Re: Planning application – 21/00026/F - 13 Blackwood Place

**GROUND FLOOR PLAN**

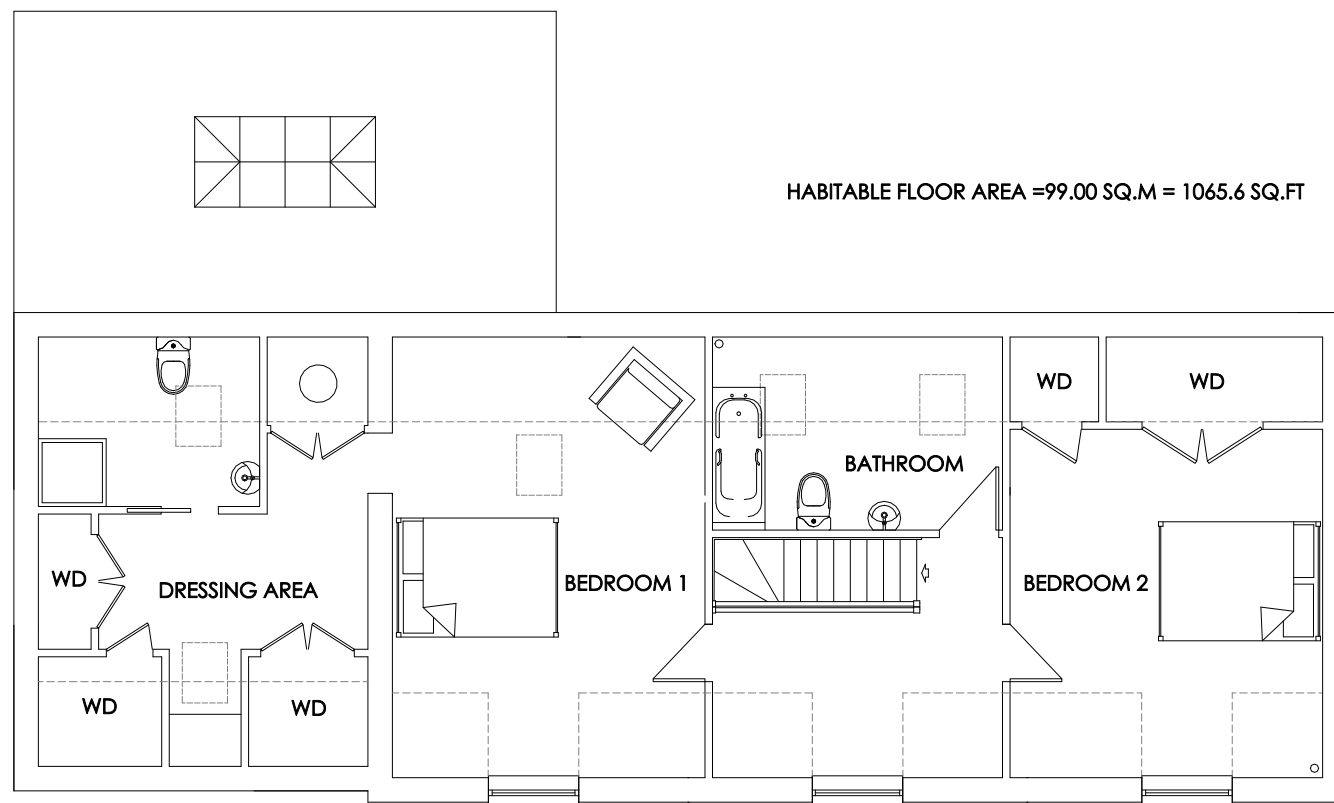
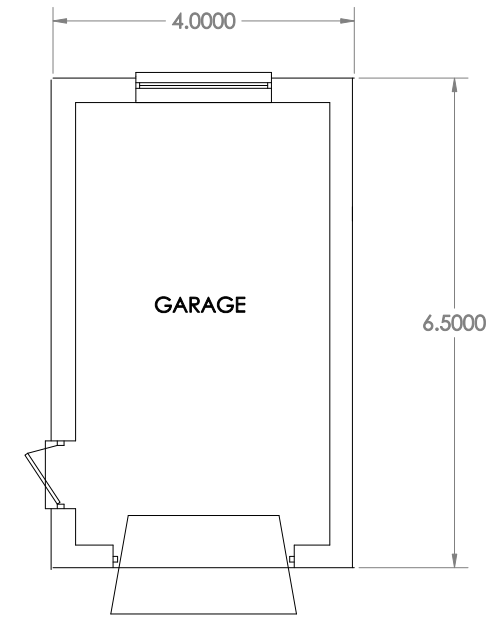
One final detail as a matter of process; the unclear layby question previously highlighted is not the sole contradiction in this application. One of the documents attached, the Combined Planning and Transport Statement indicates a two bedroom dwelling, however the floor plans show three bedrooms. This is a significant aspect of the application, pointing to future occupation, vehicle numbers and use. As such I would be concerned if consultation and a decision was concluded without clarification.
